**WELWYN HATFIELD COUNCIL – DEVELOPMENT CONTROL**  
**DELEGATED REPORT**

<b>APPLICATION No:</b>	<b>S6/2008/2412/FP</b>
------------------------	------------------------

This application seeks full planning permission for erection of part two storey rear extension, first floor bay window and replacement garage to the side and front of the existing house.

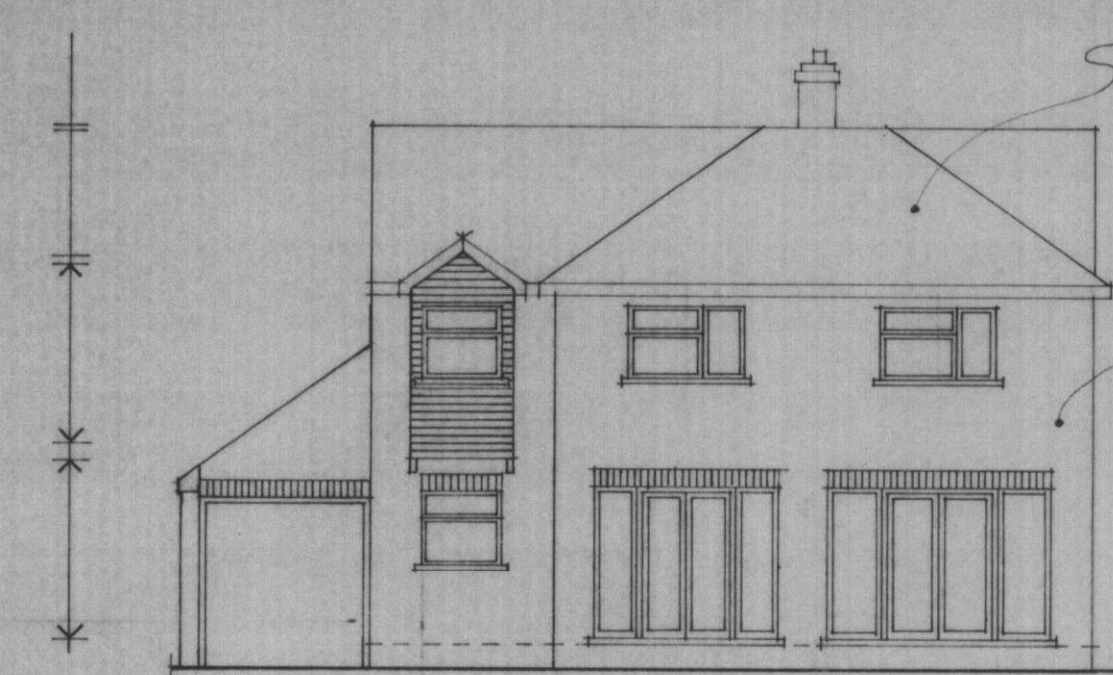
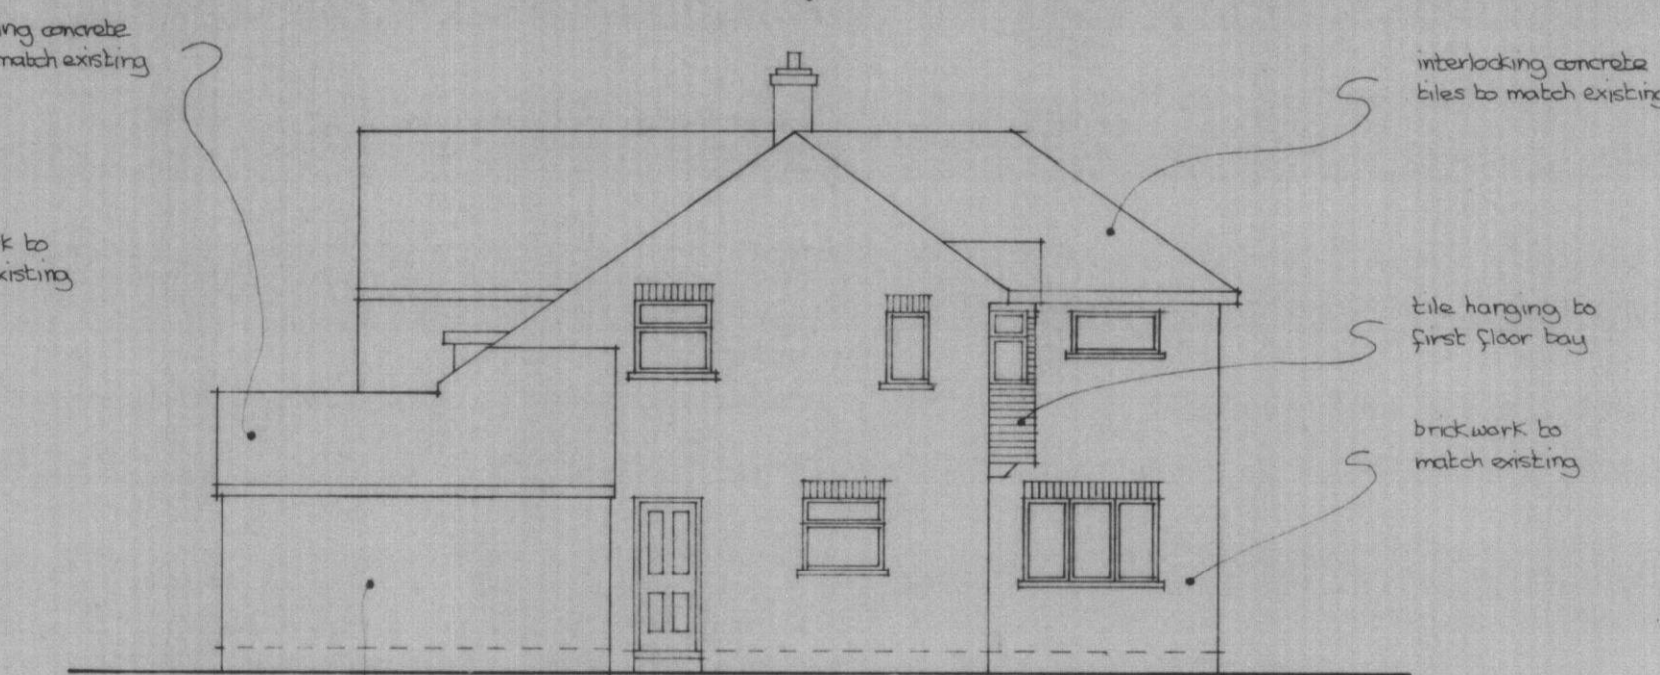
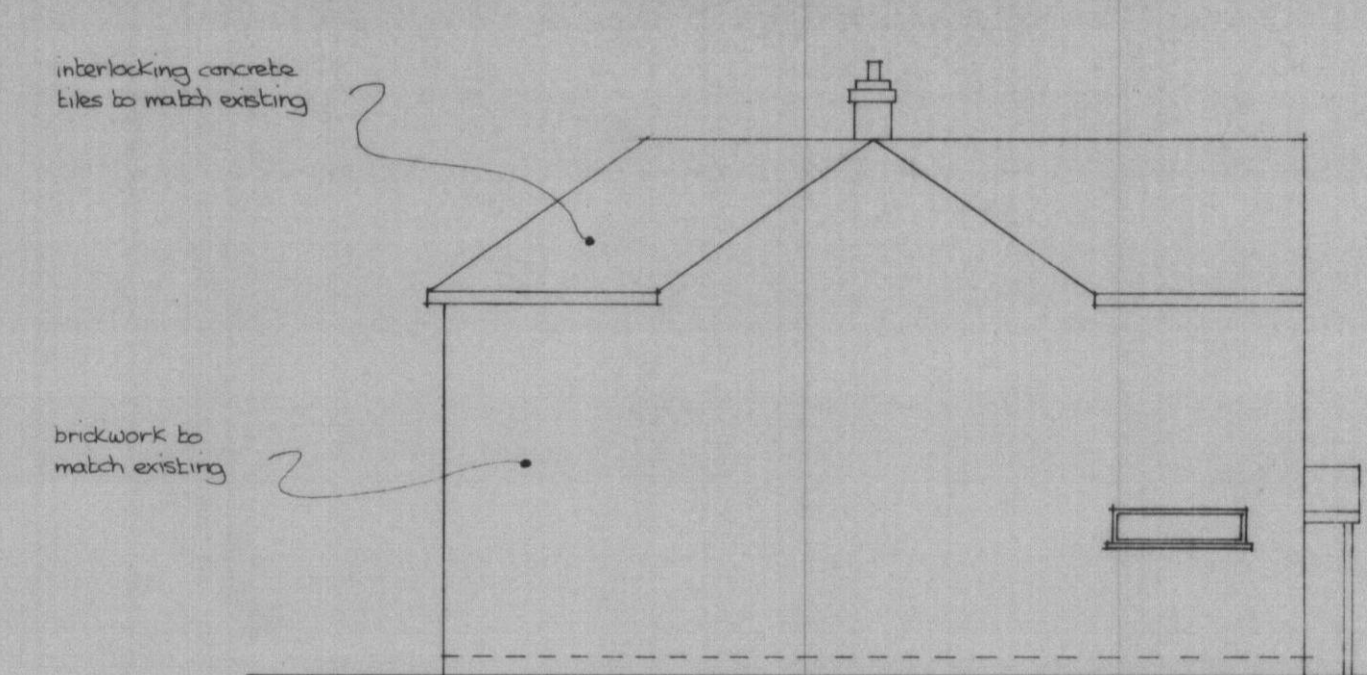
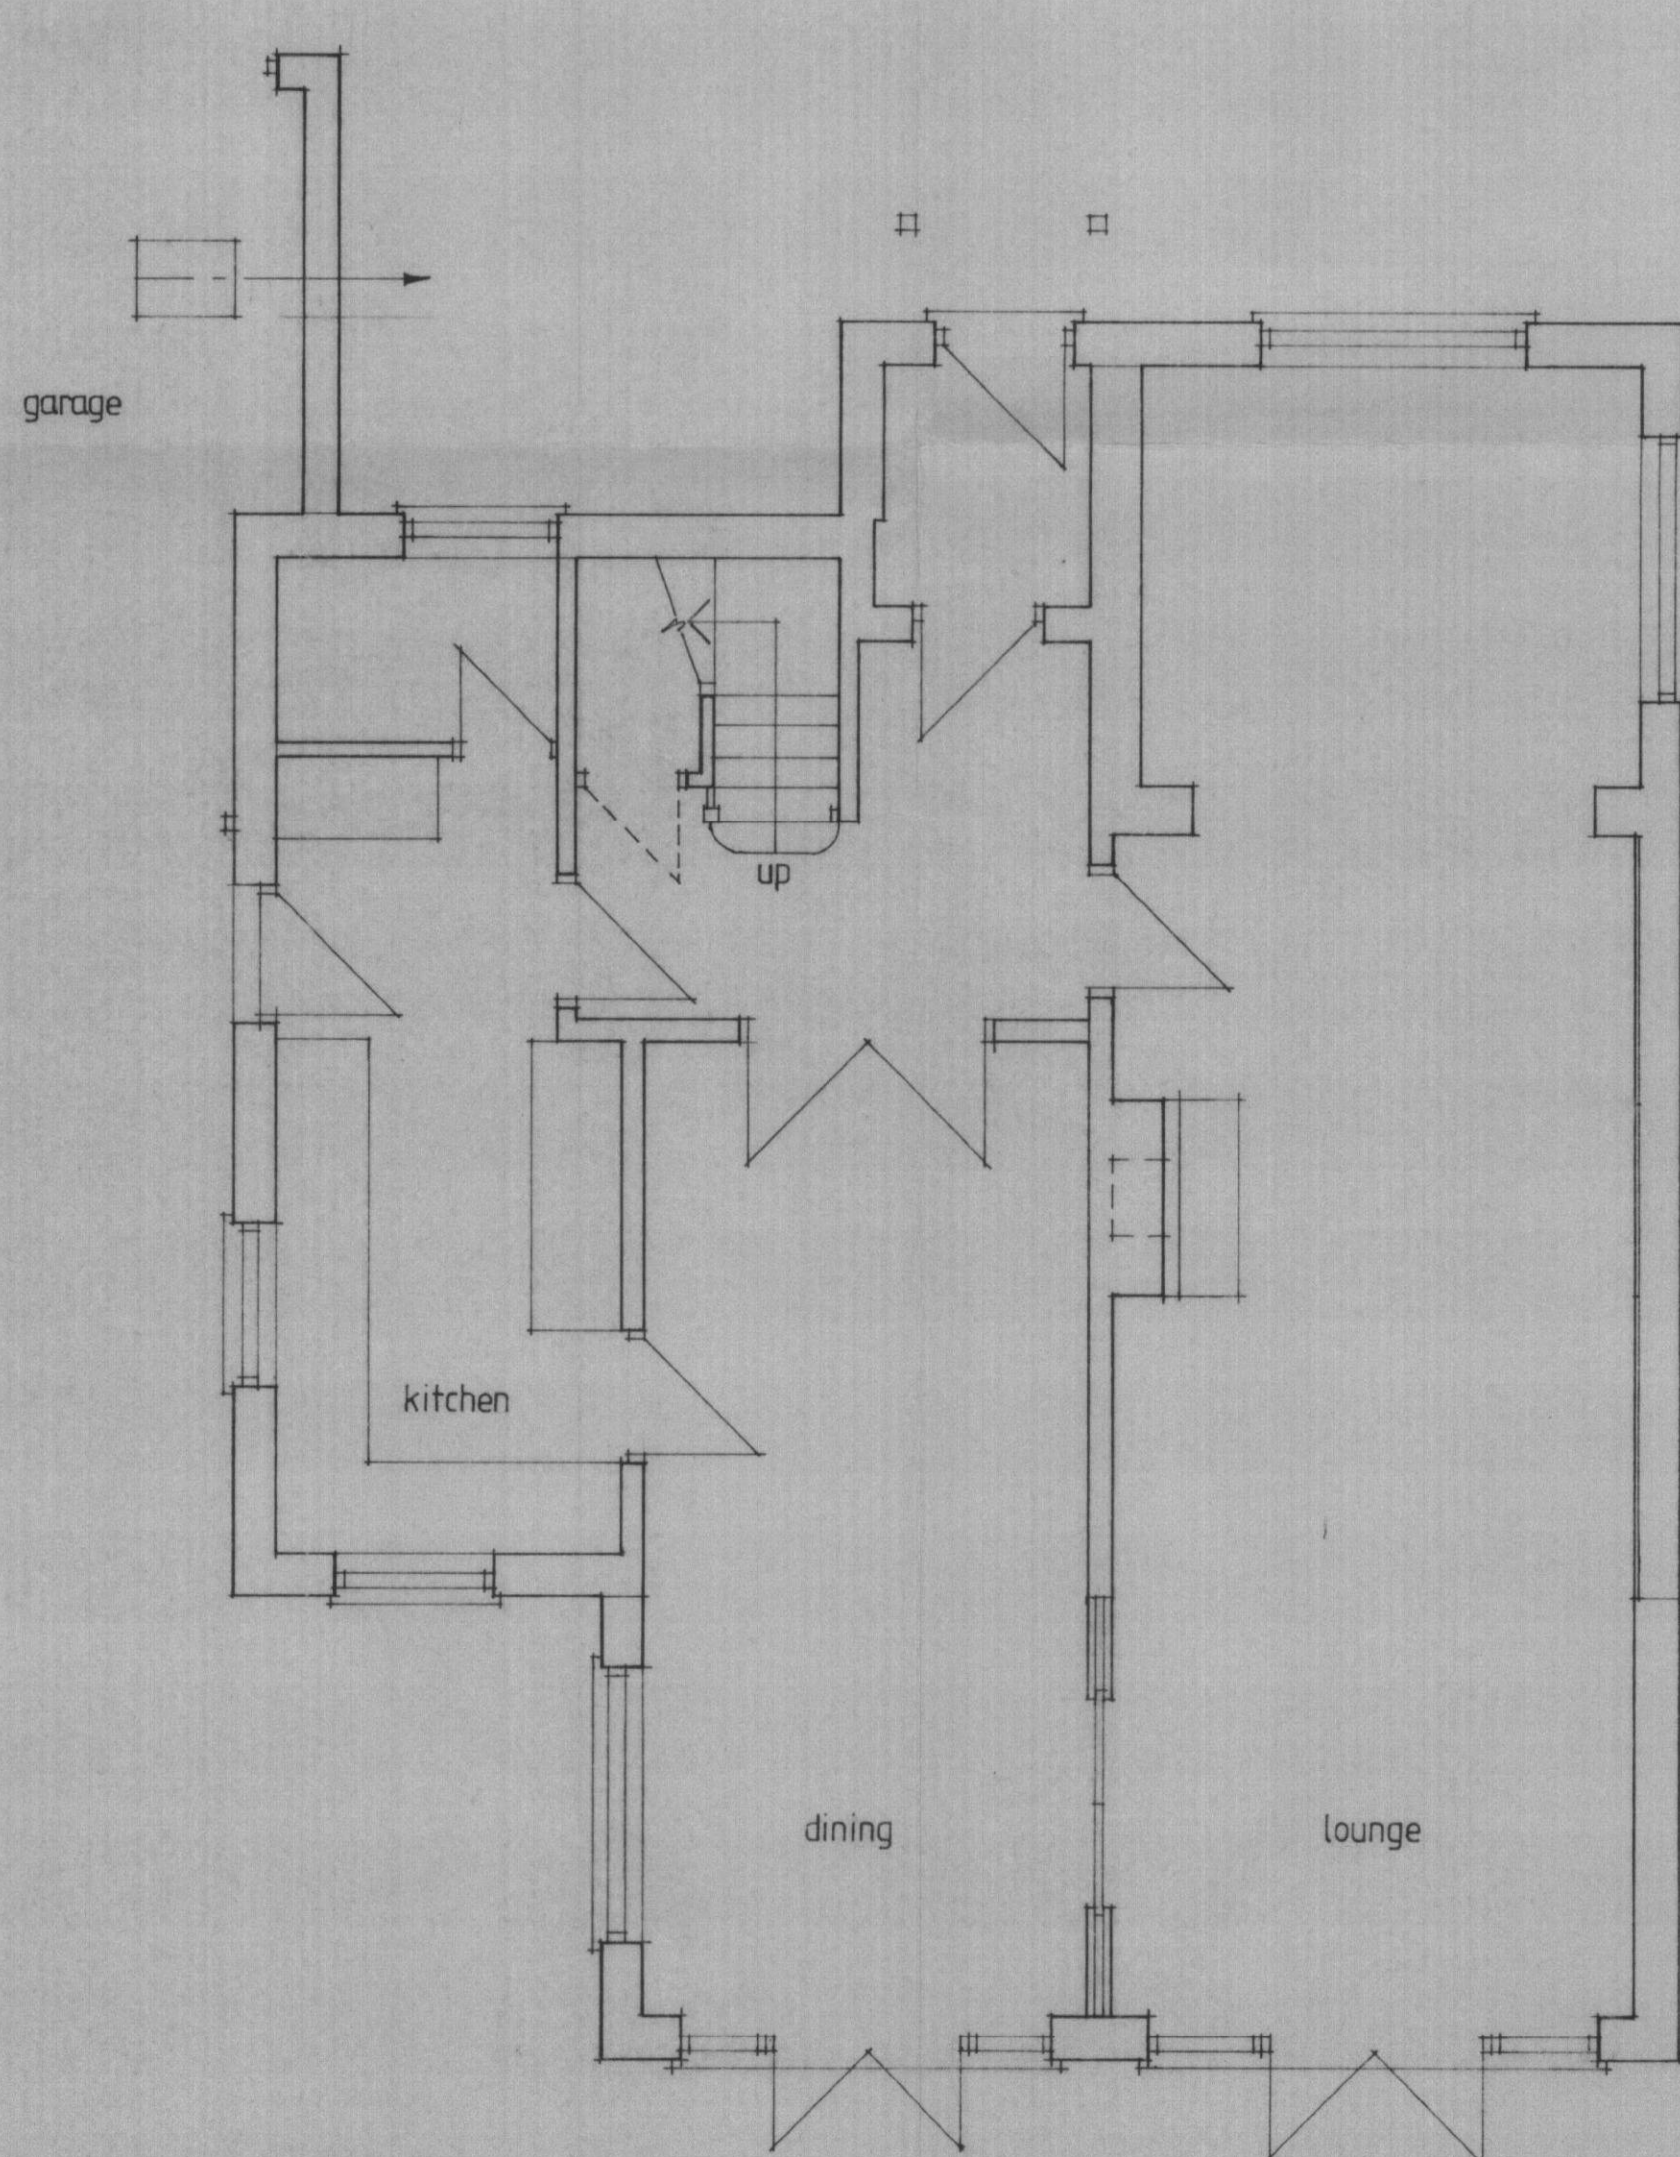
REASON: The amended plans for the garage submitted on the 13<sup>th</sup> Jan have not been updated with a proposed roof plan. Details are required to ensure that the design is in accordance with policies D1 and D2 of the Welwyn Hatfield District Plan 2005.

1. C.2.1 – Time Limit
2. C.13.1 – The development/works shall not be started and completed other than in accordance with the approved plans and details 0801/03C received and dated 13 February 2009
3. C.5.2 – Matching Materials
4. C.7.9 – Fixed and Obscure Glazing (The north flank elevation of the proposed extension and the north facing window within the first floor bay)
5. Prior to the commencement of the development hereby approved, details of the proposed roof plan shall be submitted to the Local Planning Authority for approval in writing. Subsequently the development shall be built in accordance with the approved details
